GATWICK AIRPORT NORTHERN RUNWAY PROJECT

Planning Inspectorate's Reference: TR020005

**Legal Partnership Authorities Response to Actions Arising
at ISH8 [\[EV17-018\]](#)**

Comments on Design and Access Statement - Appendix 1 -Design Principles (DP) Version 4 [REP5-031]

Figure 51. Proposed Site Plan - Car Park H Site

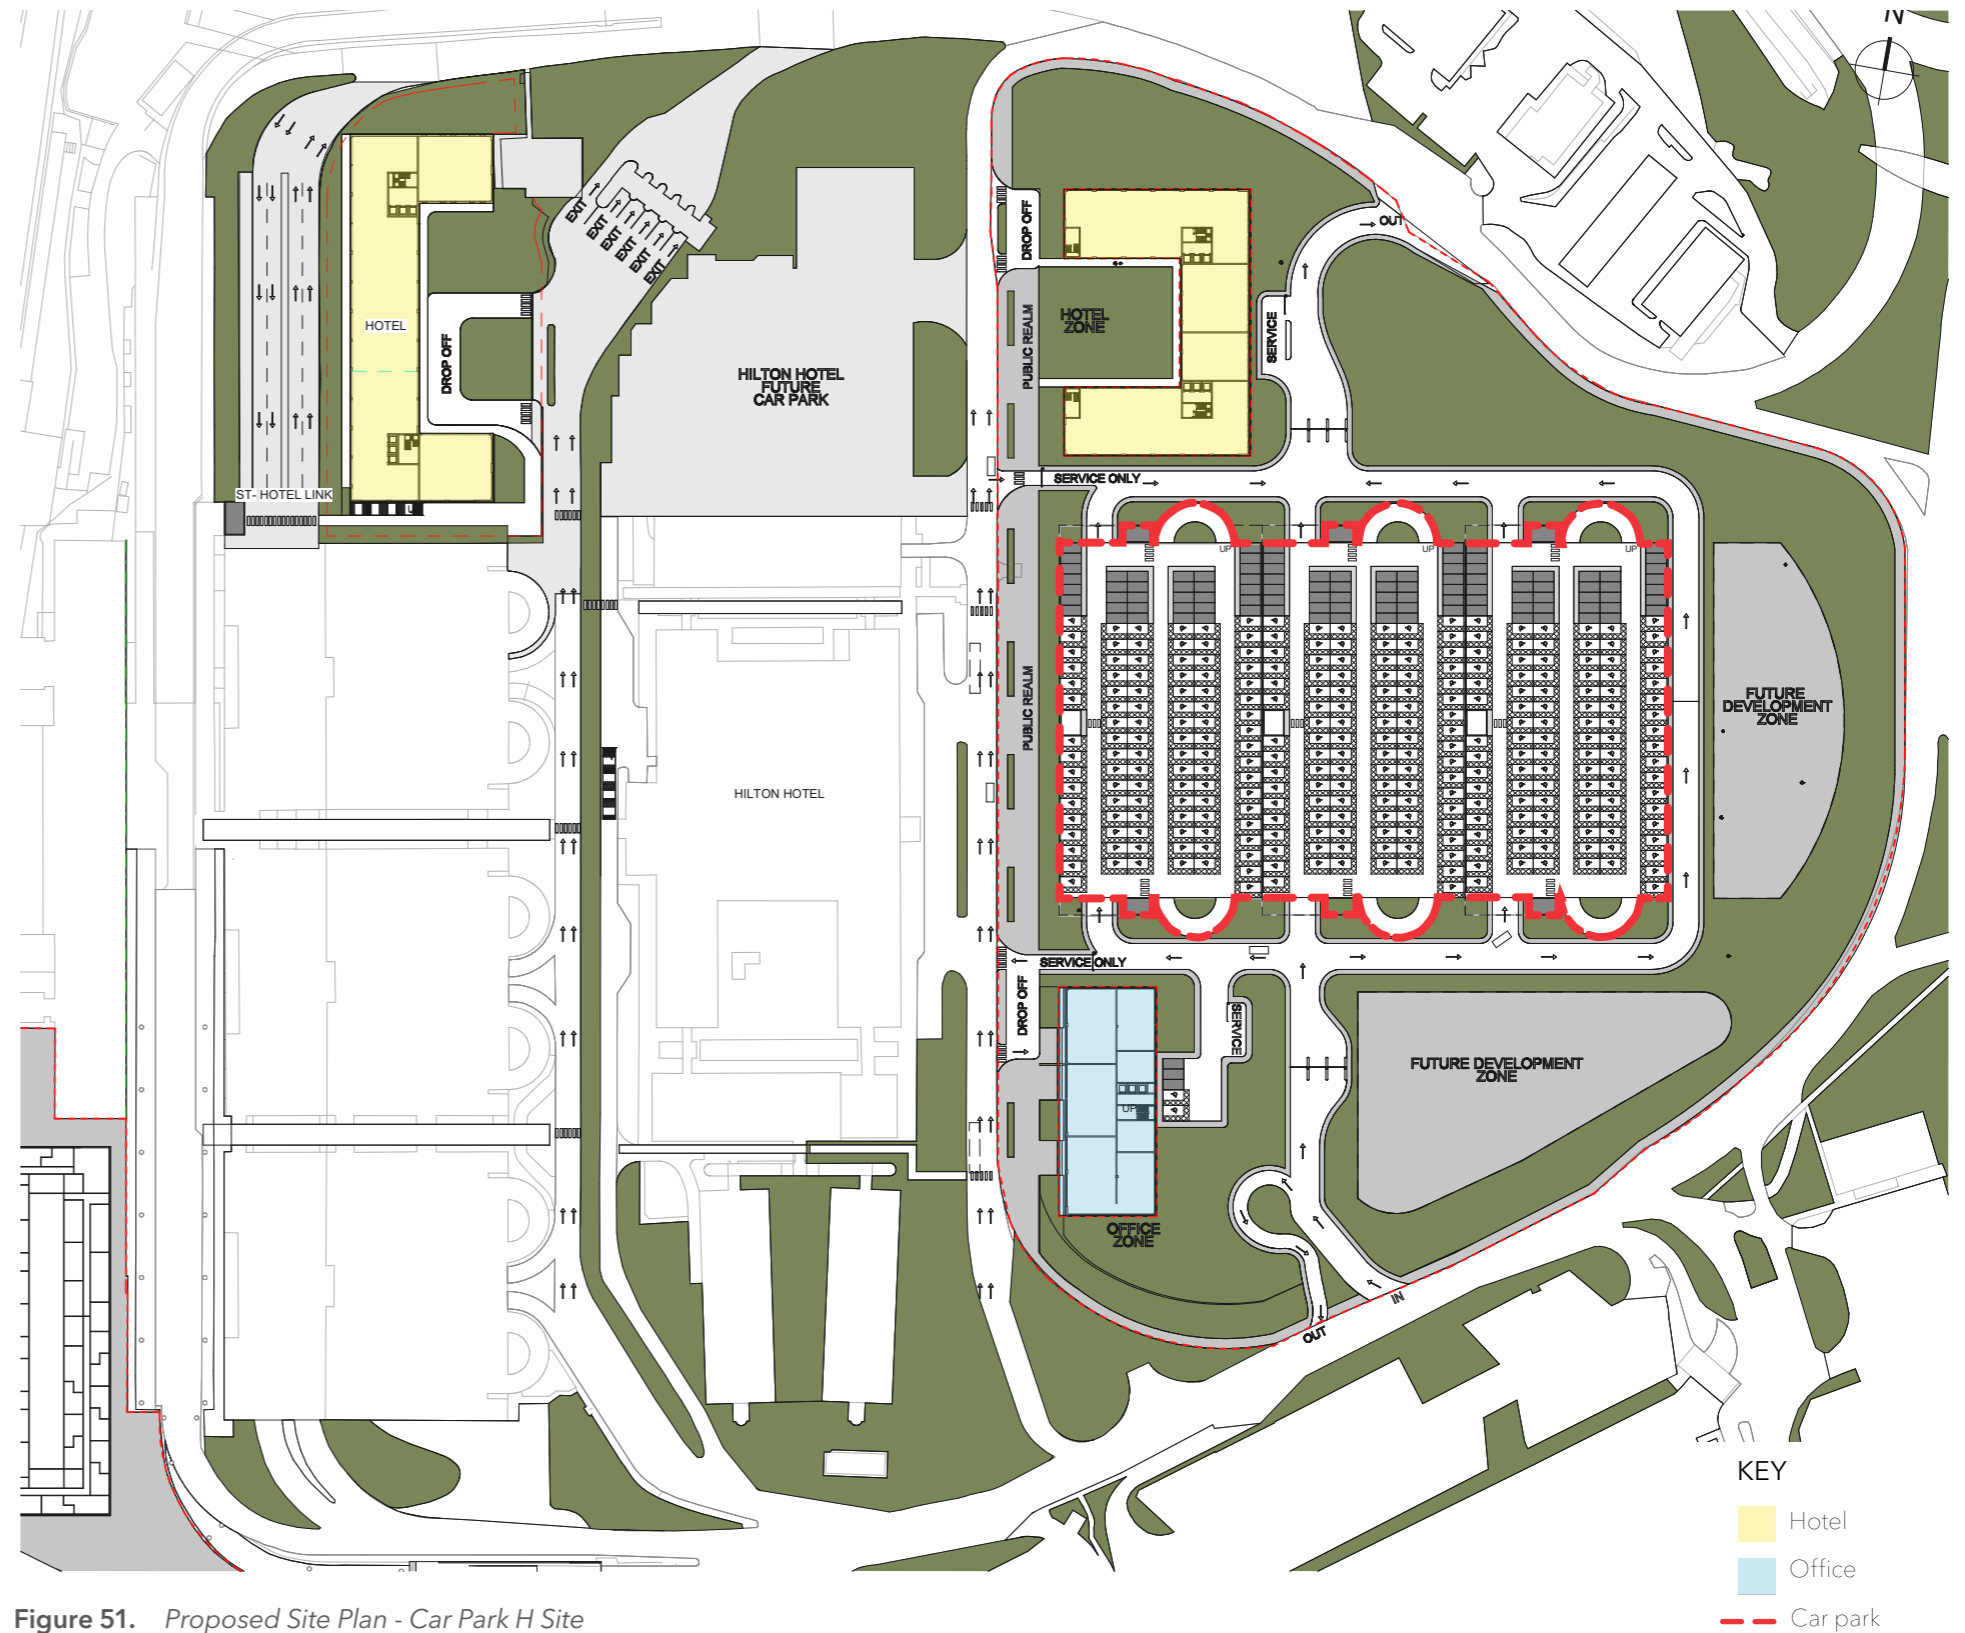
This means that the whole of the decked parking structure along that cross-section, up to the western edge, could be up to 11 metres above datum level. In addition, as the Authorities understand it, any ancillary or related development of the type listed at the end of Schedule 1 to the DCO could be added on top of the structure, including (paragraph (e)) structures and plant, signage, CCTV poles and mountings, lighting poles and fittings “and any other permanent works required”. The Authorities note that for Work No. 28 (Car Park H Site), the parameter plans show, for “associated elements”, a dotted line above the maximum

building height level (see illustration below), and this is also noted in the relevant entry in Schedule 13. It is not clear from the DCO or the plans whether this means that the Applicant does not intend to provide any associated elements on the top of structures where no such dotted line is shown. This could be made clearer in the DCO, the parameter plans and in Schedule 13.

So in order to meet the Authorities’ concerns, there would need to be a change in which Schedule 13 is structured. For example, rather than it being simply illustrative of what the parameter plans say, instead it could impose detailed restrictions on the parameter heights at certain places within the works area and impose restrictions on what ancillary and related development may be constructed (if any) above the parameter heights for each work. Or the authorities’ objective could be achieved by changes to the works plans and/or parameter plans themselves, or to article 6 (limits of works) to the DCO, in the case of “associated elements”.

Figure 67. Airfield View of Pier 7

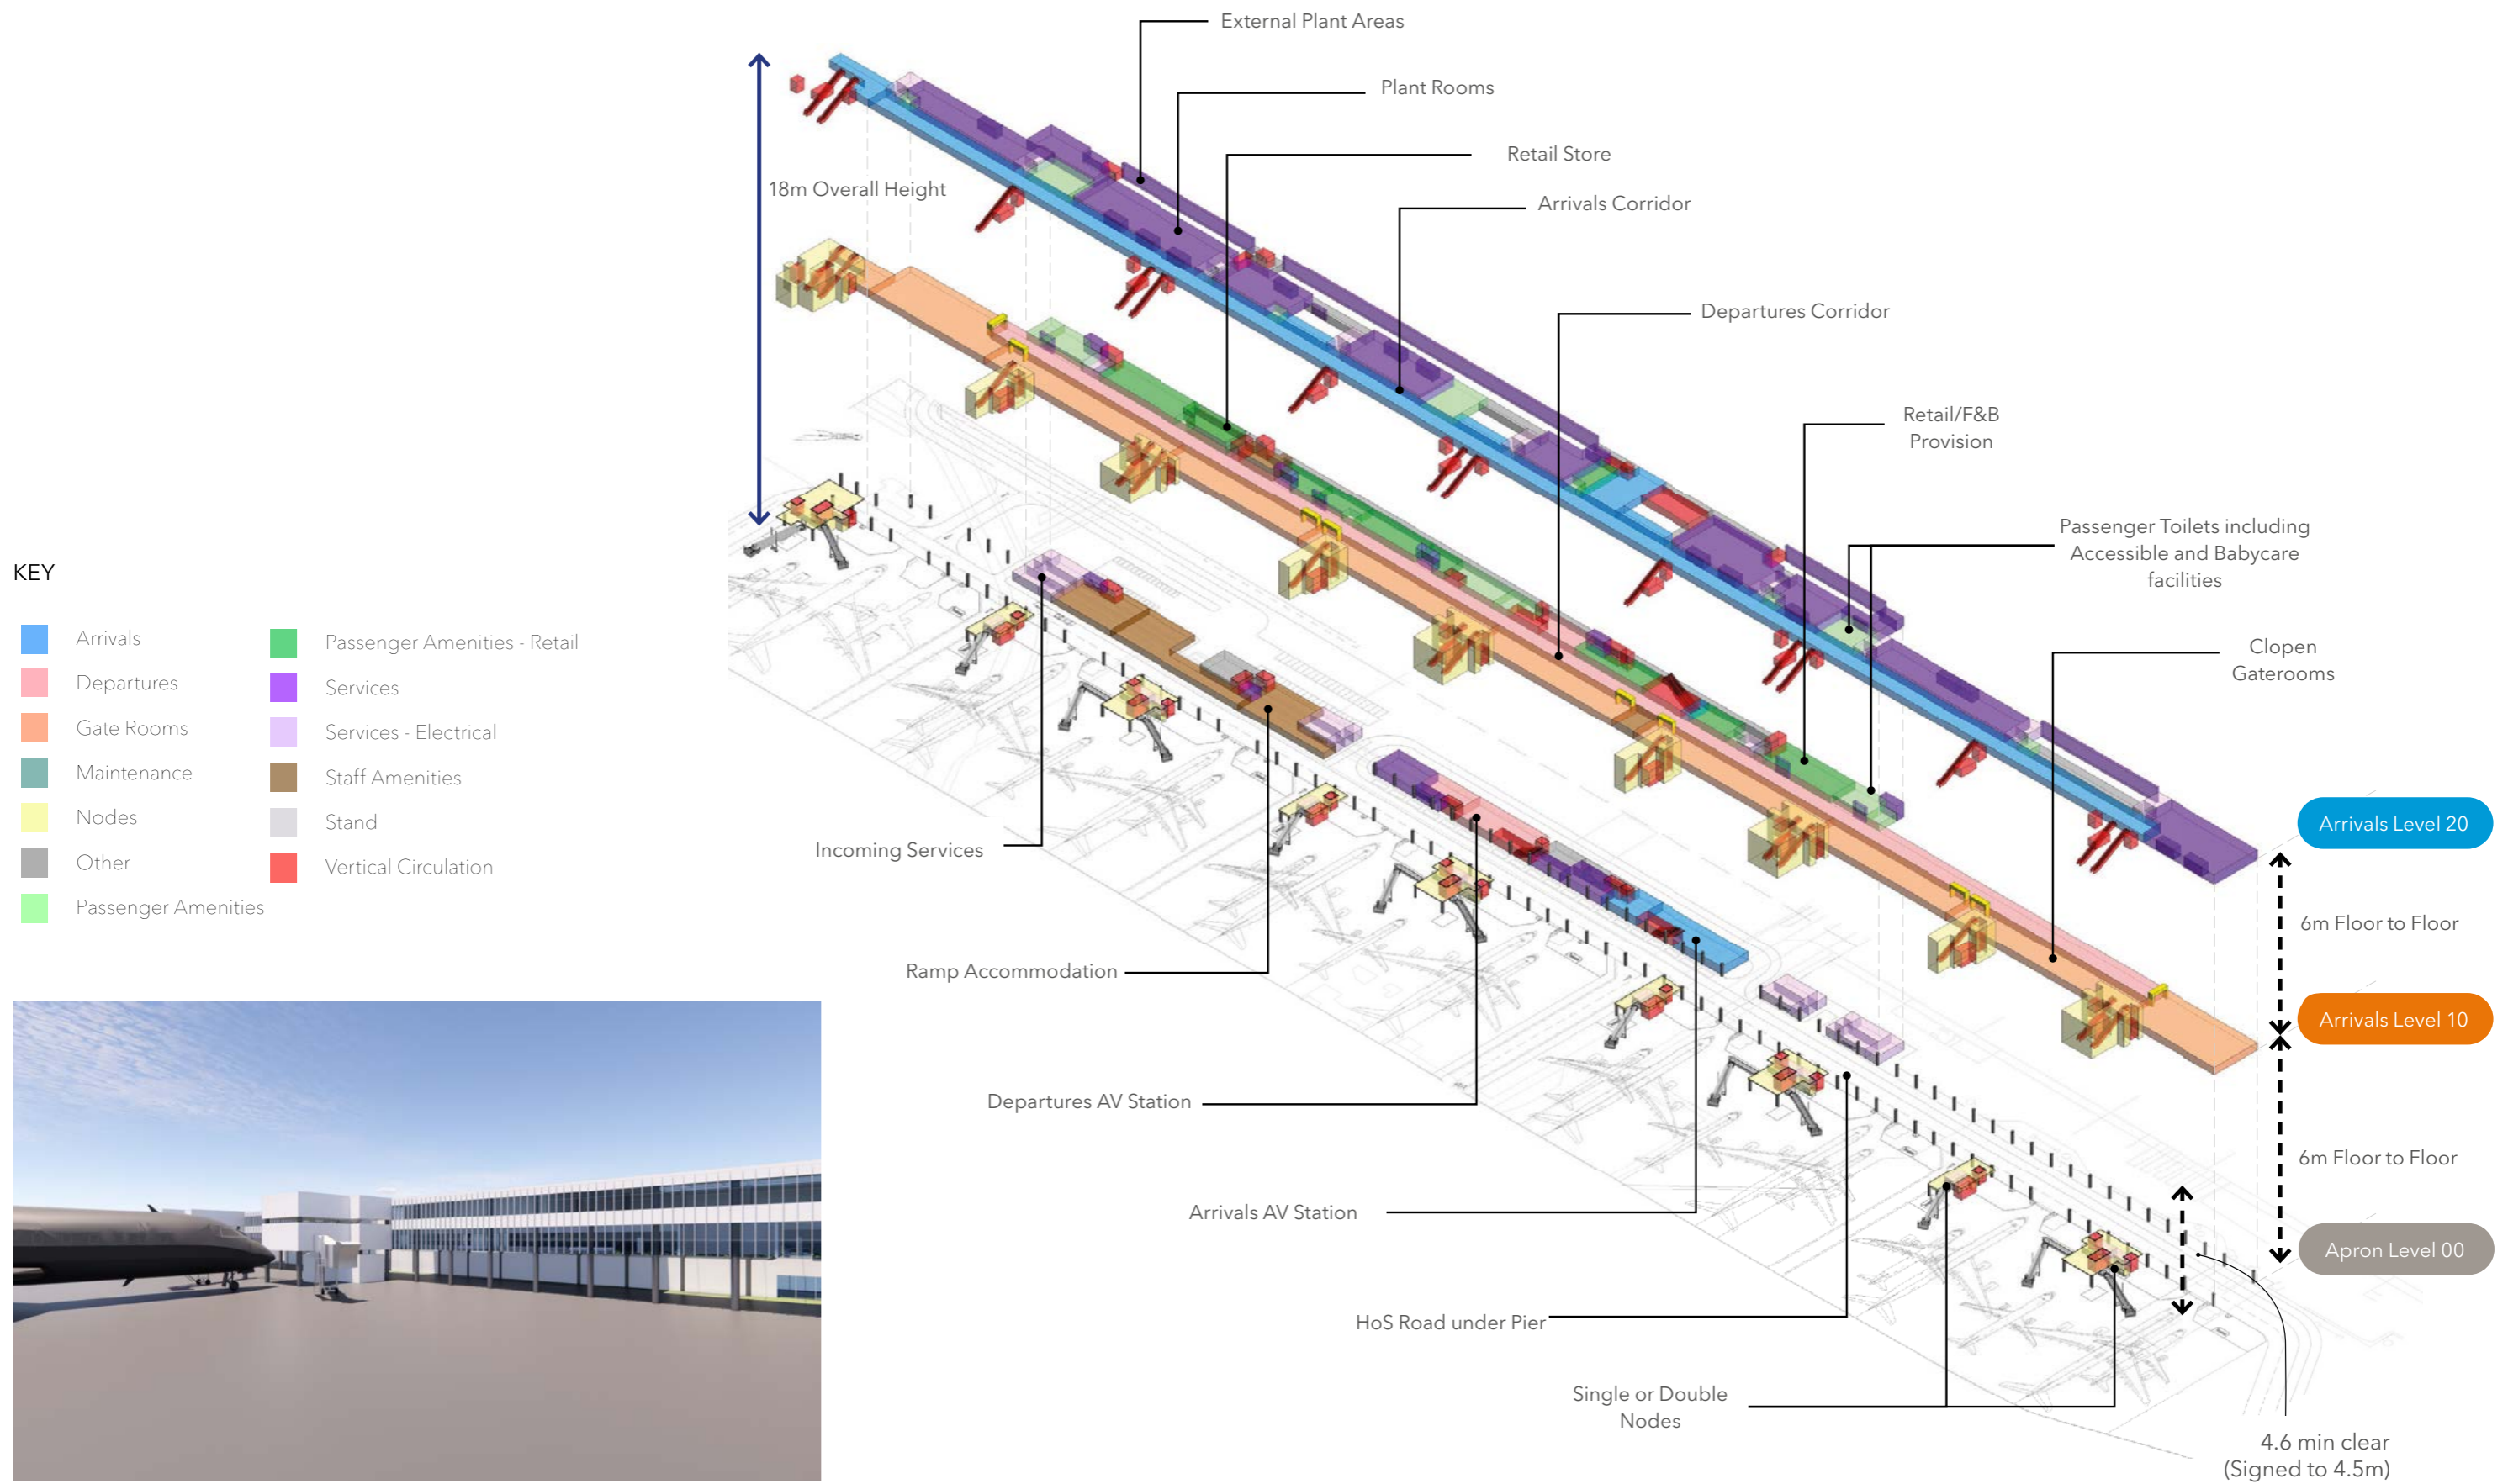
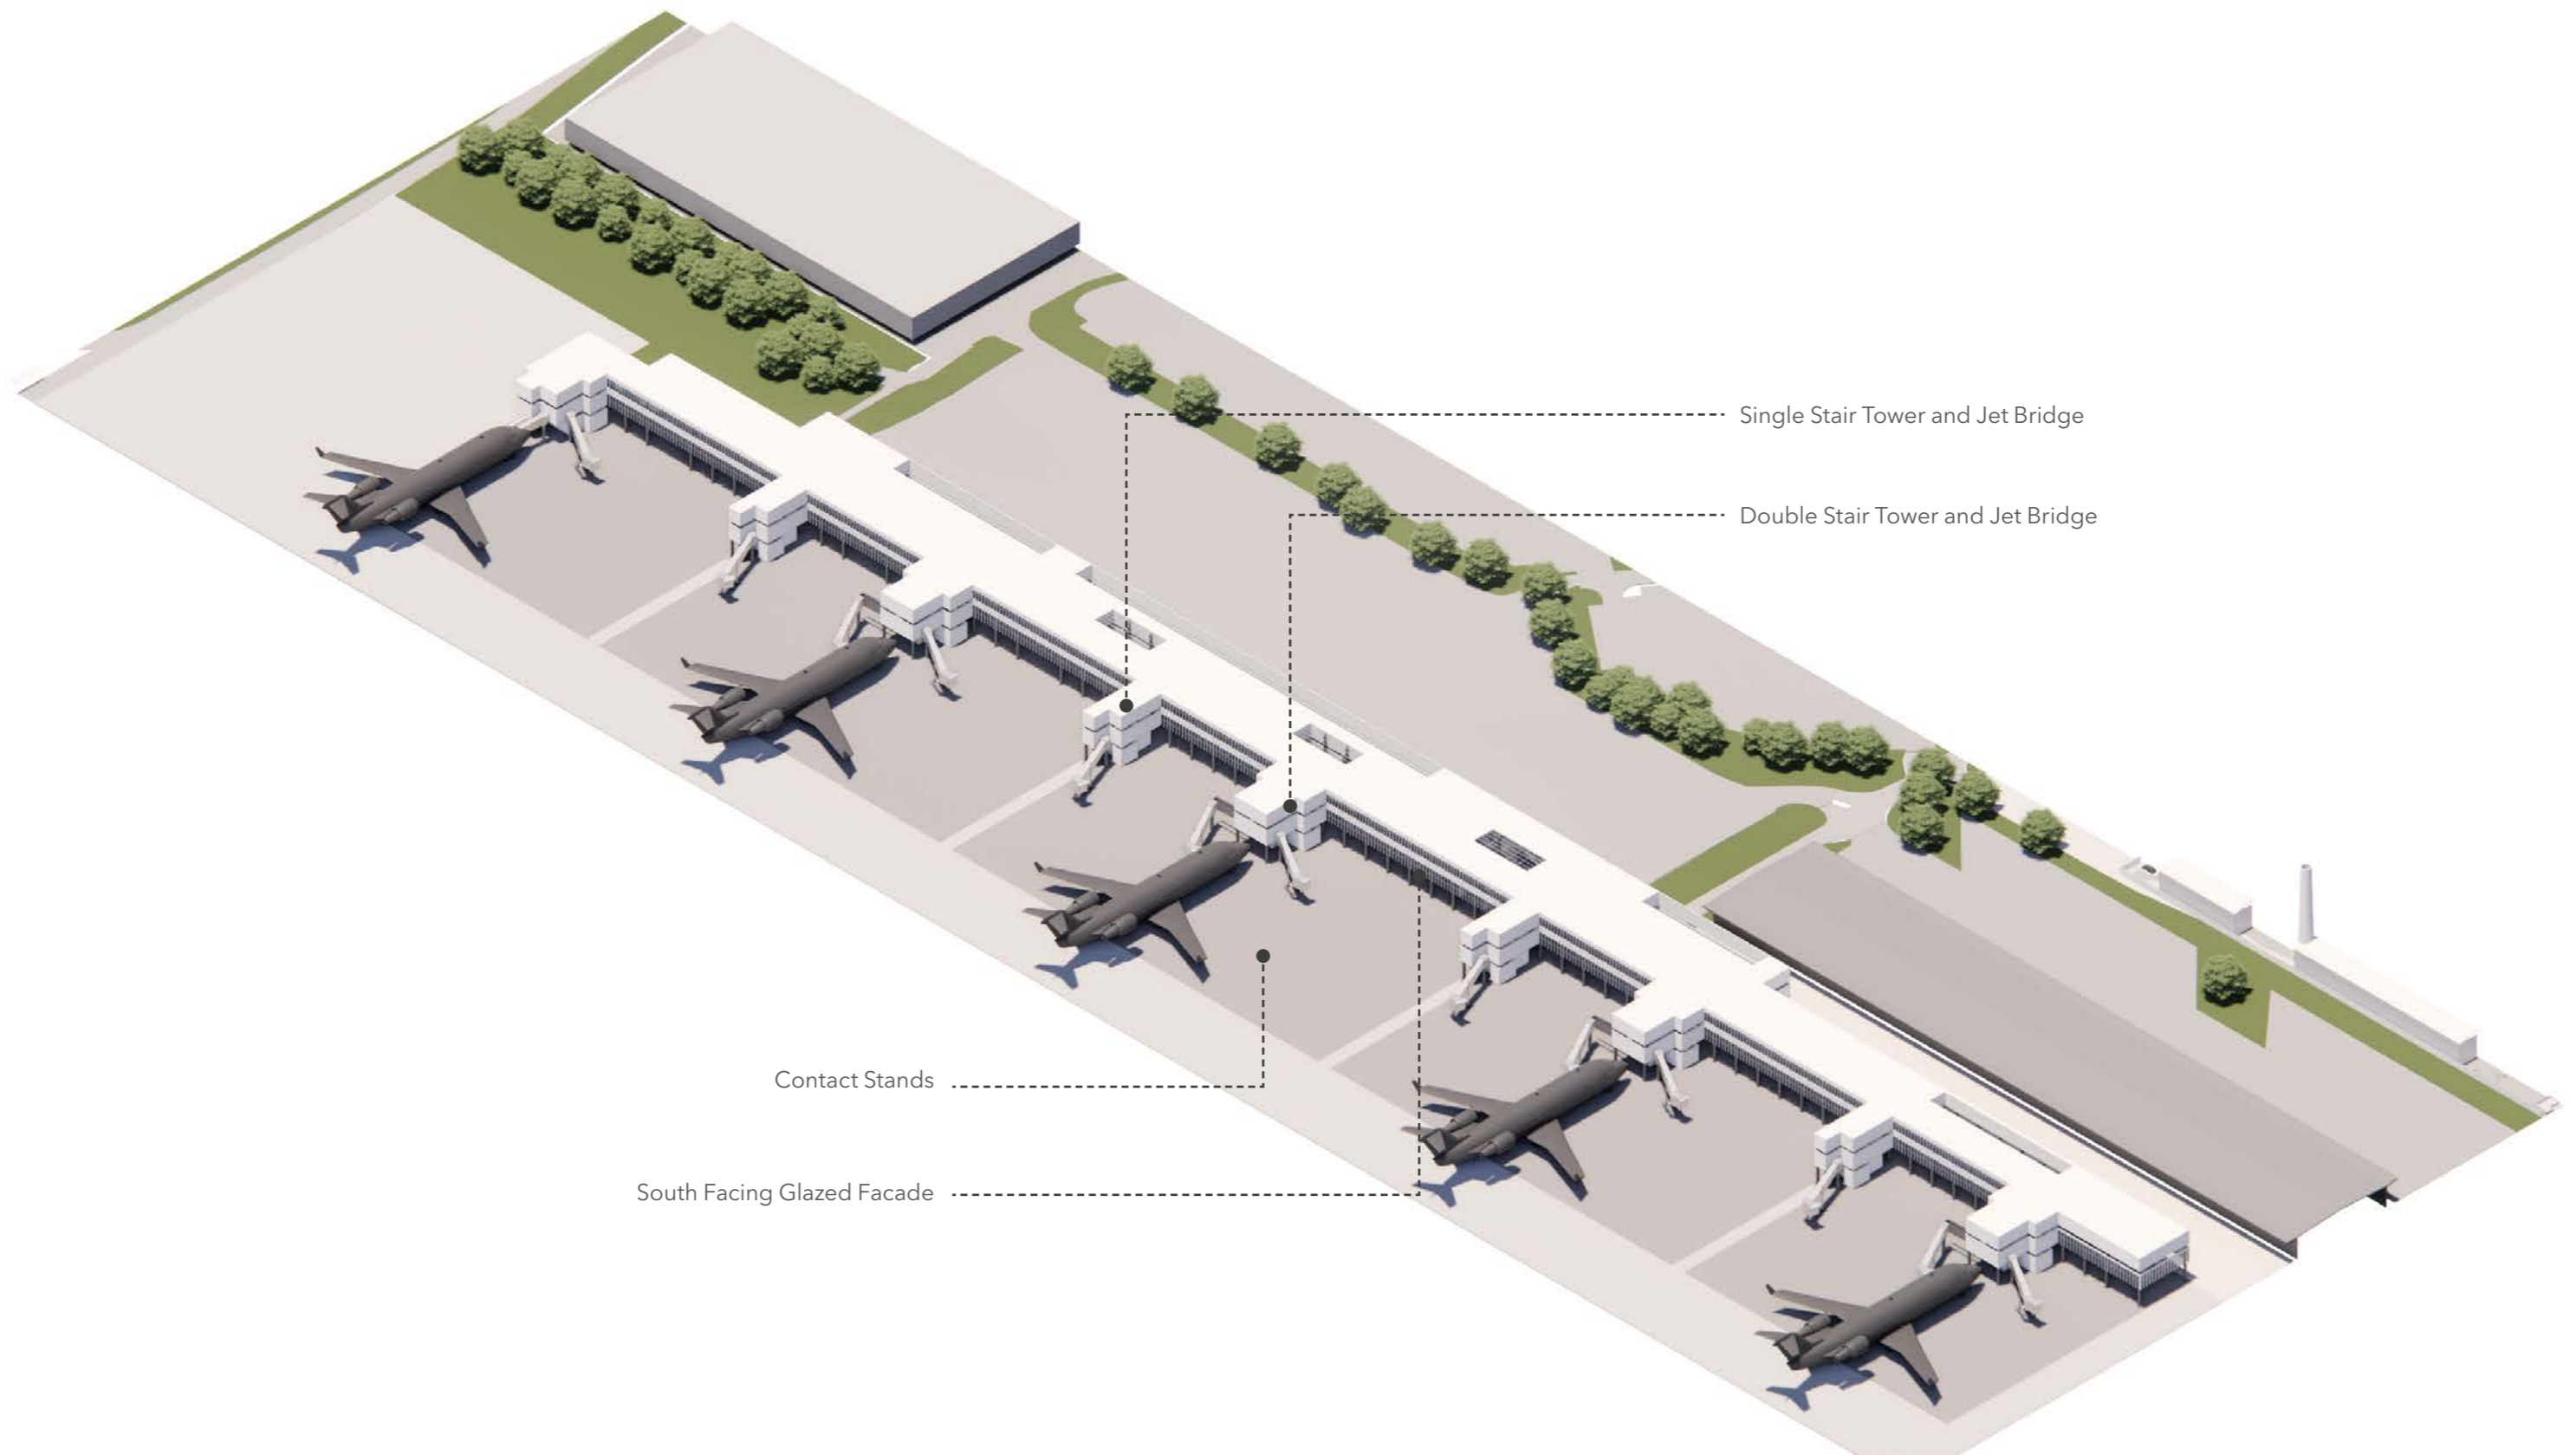
6	Pier 7	This is a significant building (major scale development) which would be visible within the airfield and needs to be considered in terms of its design quality and sustainability measures
7 – to be confirmed	Oscar Area	This covers the same land as Works Area 8. There is no detail in DBF51 or DBD52 to explain what the design and appearance of these works would be and on indication on indicative layout. It is unclear if there are any implications for drainage.
9	Central Area Recycling Enclosure	Please see Table 2 (request for design review).
